WEST SUSSEX COUNTY COUNCIL CONSULTATION

TO:	Arun District Council FAO: Amber Willard
FROM:	WSCC - Highways Authority
DATE:	4 August 2021
LOCATION:	Corner of Westergate Street and Meadow Way, Aldingbourne, PO20 3QT
SUBJECT:	AL/96/21/TEL Prior notification under Schedule 2, Part 16, Class A for H3G phase 8 1.5m high street pole c/w wrap around cabinet & 3 further additional equipment cabinets.
DATE OF SITE VISIT:	n/a
RECOMMENDATION:	Advice
S106 CONTRIBUTION TOTAL:	n/a

215 PROPOSED SITE PLAN

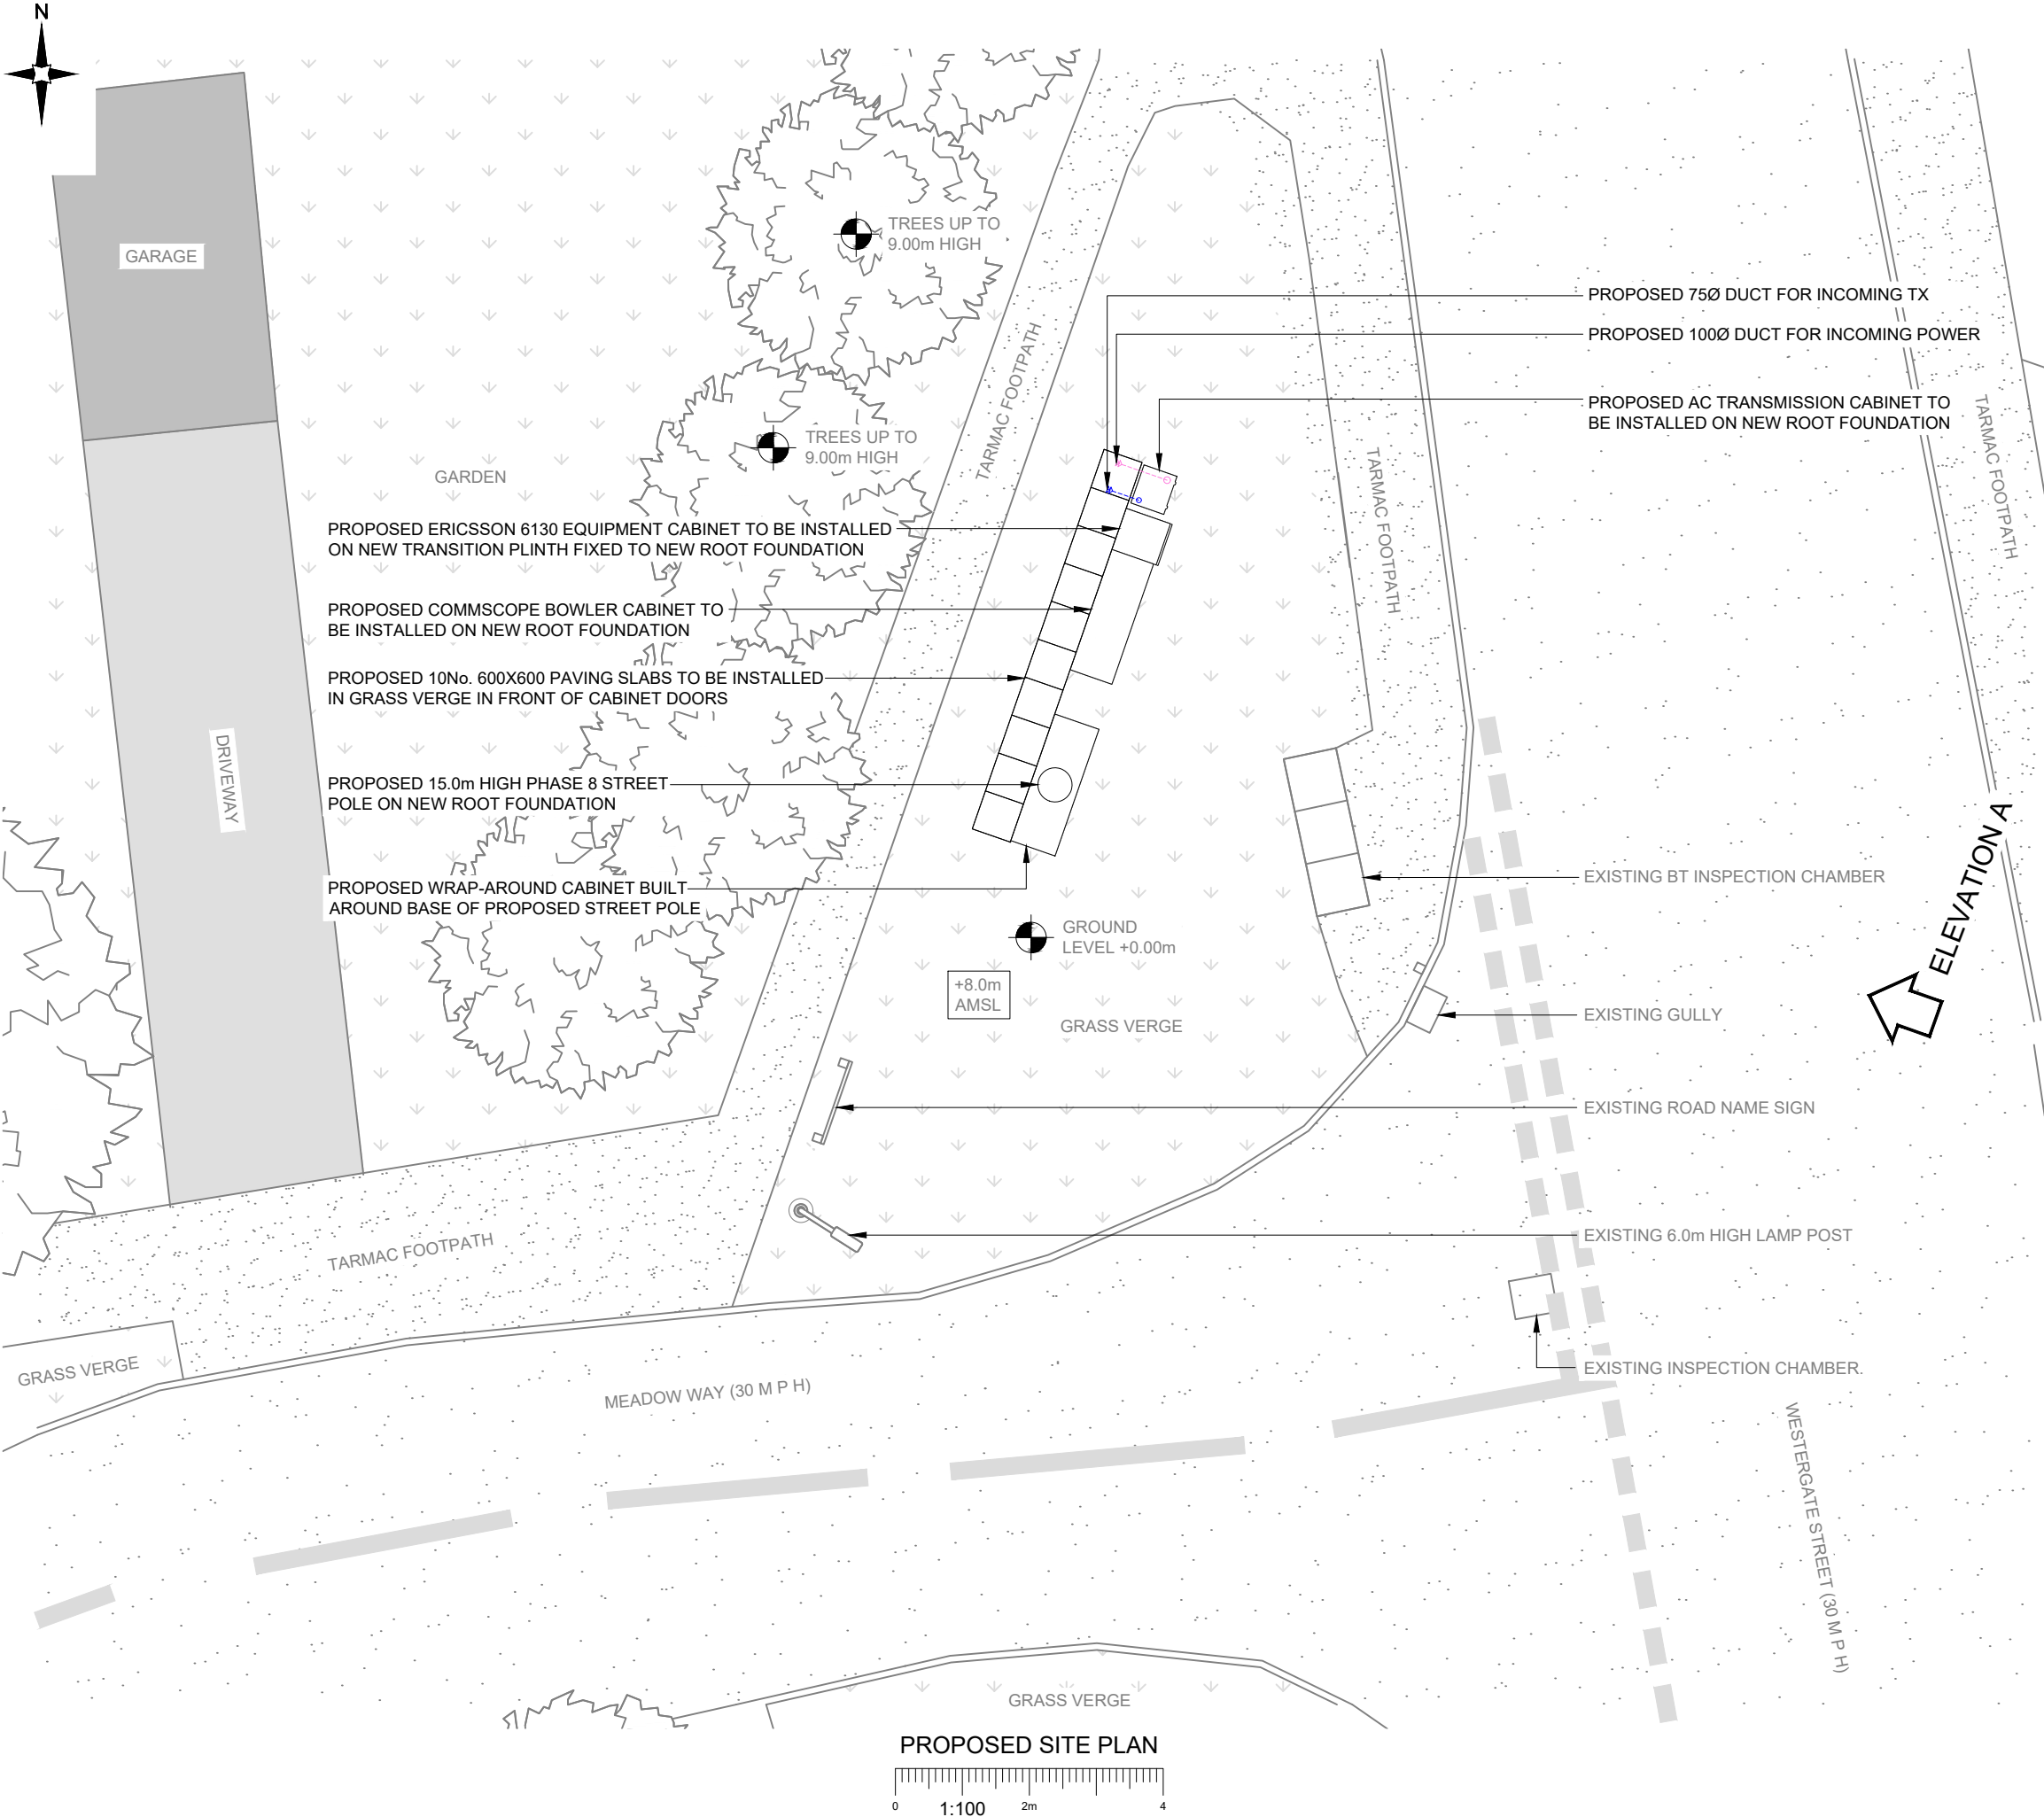
The proposed telecommunications equipment is to be located within highway boundary.

The proposed location is not anticipated to obstruct visibility for vehicles making use of the Westergate Street and Meadow Way junction. Nor will the location obstruct the free flow of pedestrian movements in this location.

The Statutory Undertaker will need to submit the necessary notification to the Highway Authority independently and any traffic management would need to be agreed with the WSCC Highways prior to works taking place.
